Re: A/54/20/HH

With regards to the planning application as referenced above, I am writing to express objections to some aspects of the application as it currently stands. I believe that these can be addressed to the satisfaction of all parties concerned and am prepared to enter into a negotiation with the applicant to agree a solution in order to support a revised application but until that is achieved, I wish my objections to be taken into account when making the decision regarding this current application:

HAPA ARCHITECTS			
Job Name			
Ariston, Water Lane, Angmering, Littlehampton			
Status	PLANNING	Drawing Type	PROPOSED SITE PLAN/ BLOCK AND PROPOSED GARAGE CONVERSION PLAN AND ELEVATIONS
Date	APRIL '20	Scale	1:50, 100 & 500 @ A1
Job Ref			WL_101
Drawing Number			L-200a

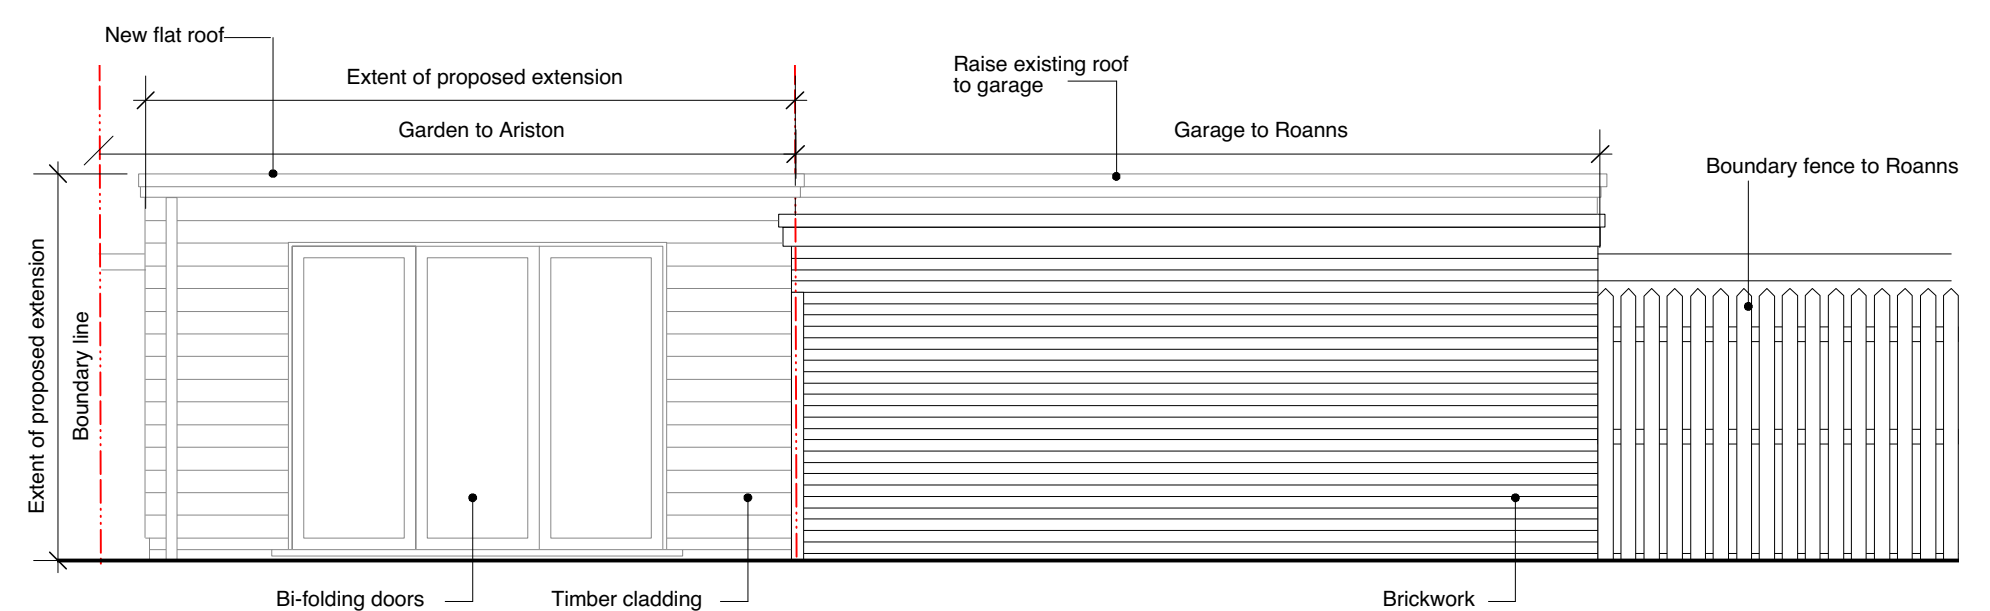
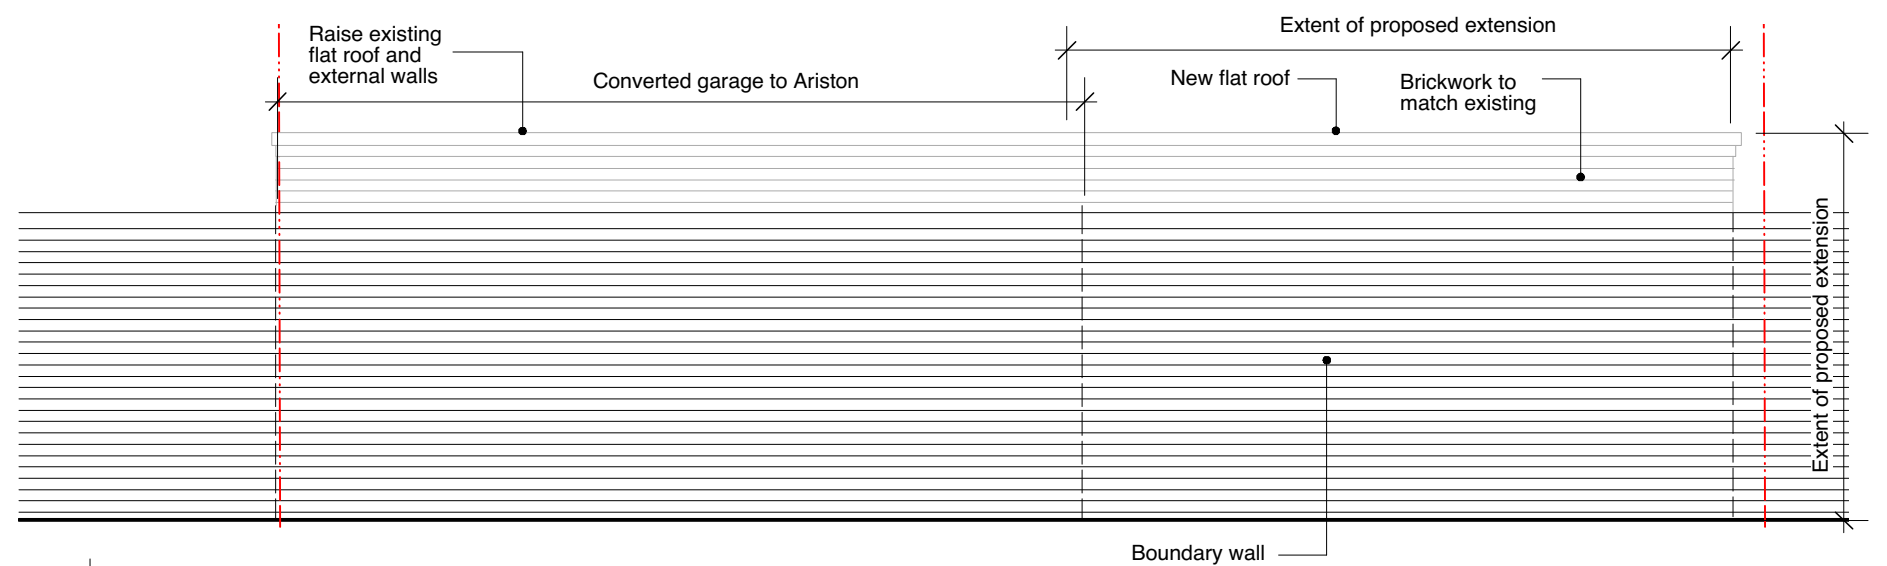
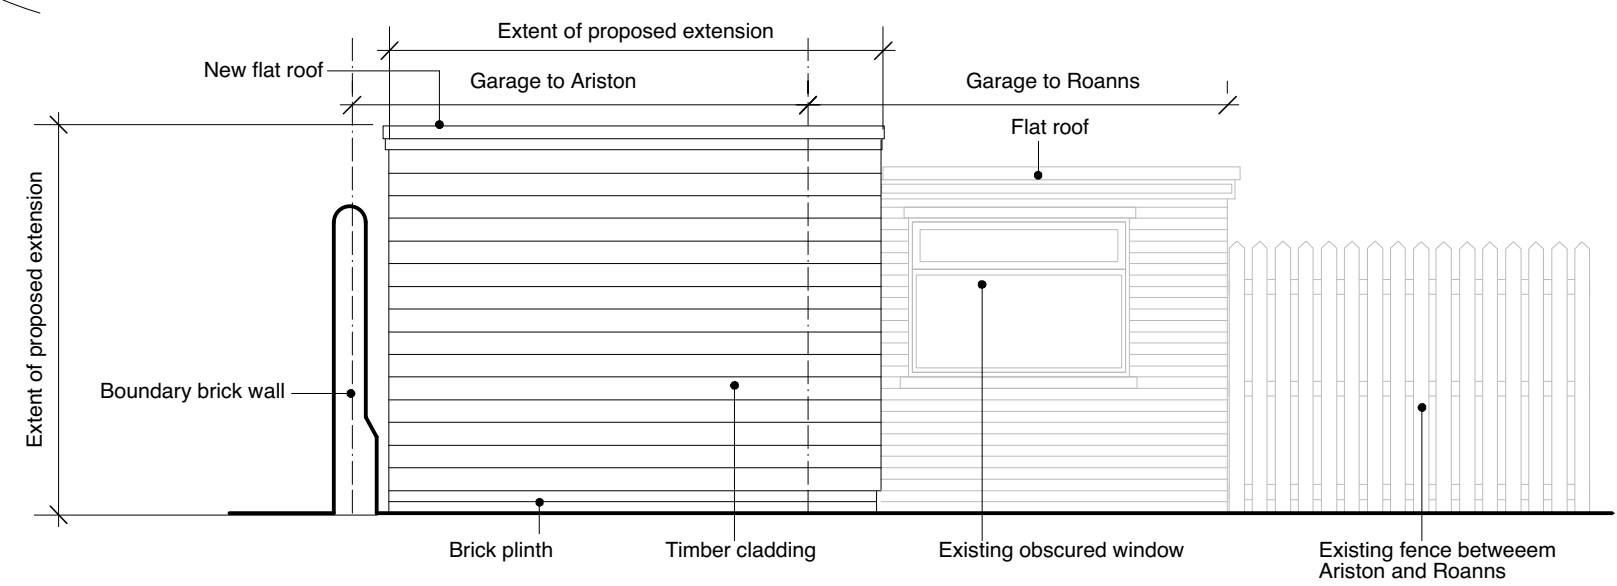
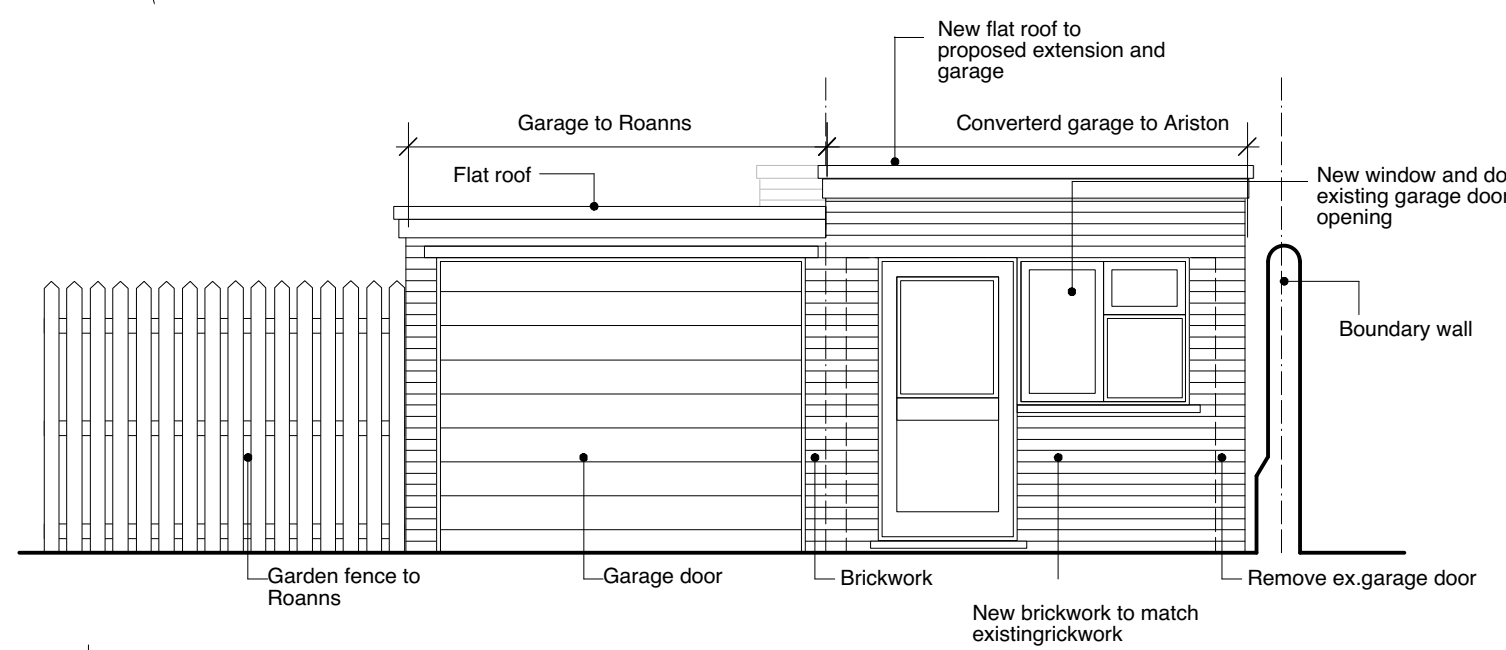
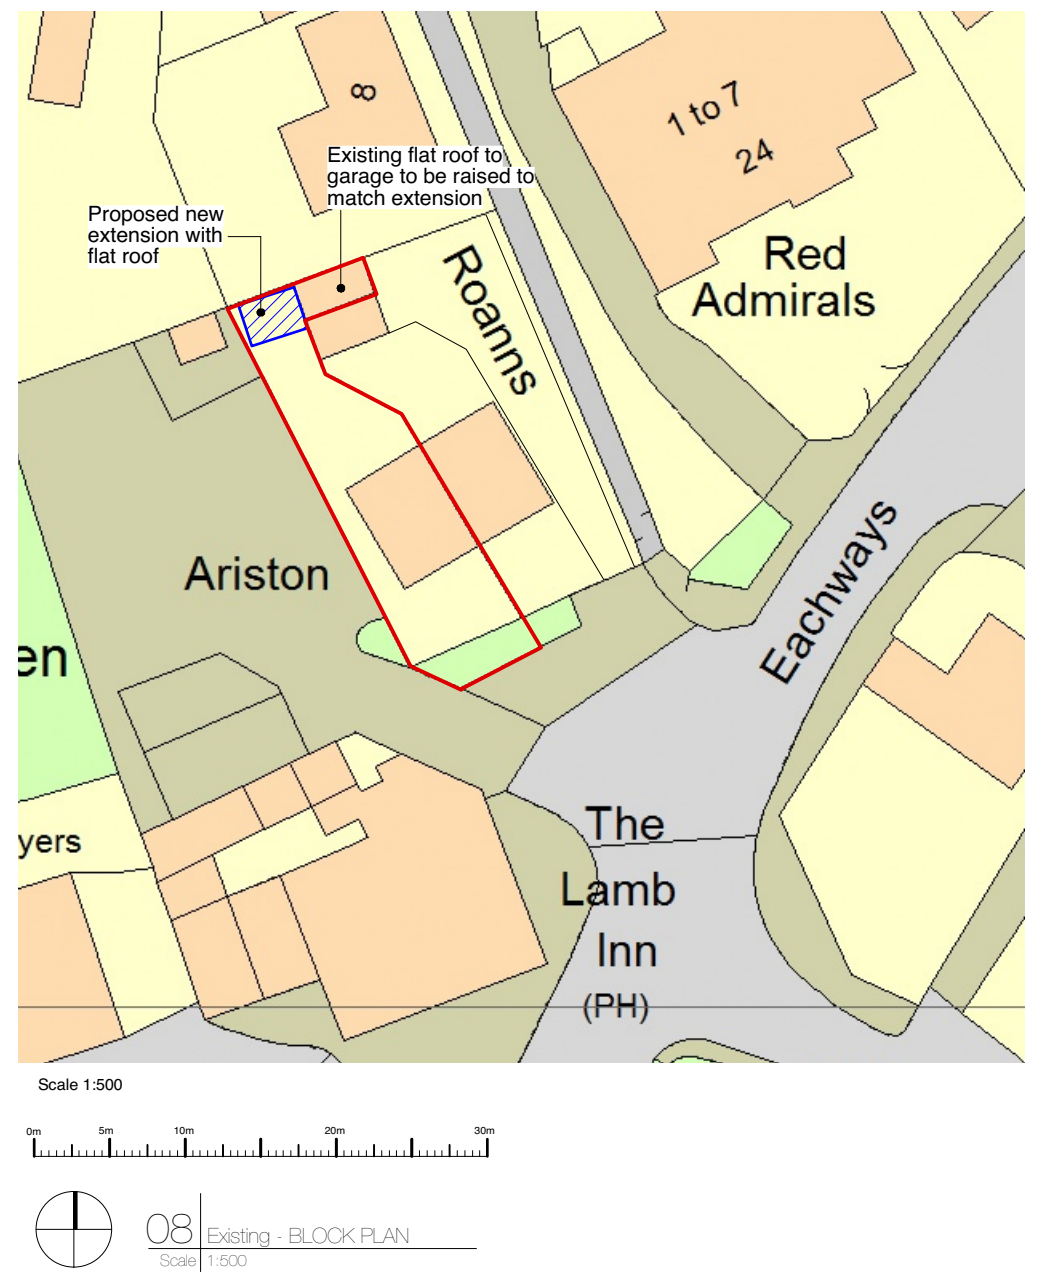
The plans submitted in respect of the application show a door and window on the east wall opening onto the land owned wholly by Roans; this would seem to suggest that the resident of the ancillary building (I have been advised by the applicant that the intended purpose of the ancillary building is to provide permanent accommodation for a relative) intends to use the land owned by Roans to access the newly created ancillary accommodation.

I object to a doorway on the east wall that will provide direct access onto land owned wholly by Roans being included into the construction.

2. Further to the above, the window on the east wall next to the door as described above will significantly reduce the privacy of the owner of Roans as this will look directly onto its private land.

I object to the window sited on the east wall of the proposed ancillary building.

3. The plans show that the existing flat roof shared by both garages will be replaced by an elevated section on the new construction; however, the plans do not appear to provide for any guttering that will drain surface water away from the elevated section to be captured within the boundaries of Ariston, instead implying that it will fall onto the flat roof of the garage owned by Roans.

Until revised and more detailed plans are submitted that demonstrate appropriate guttering is included **I object to the change from a shared flat roof to one with an elevated section on the ancillary building.**

4. The plans do not mention creating a firewall between the proposed ancillary building and the adjacent garage owned by Roans, nor do they show electric, water and waste arrangements.
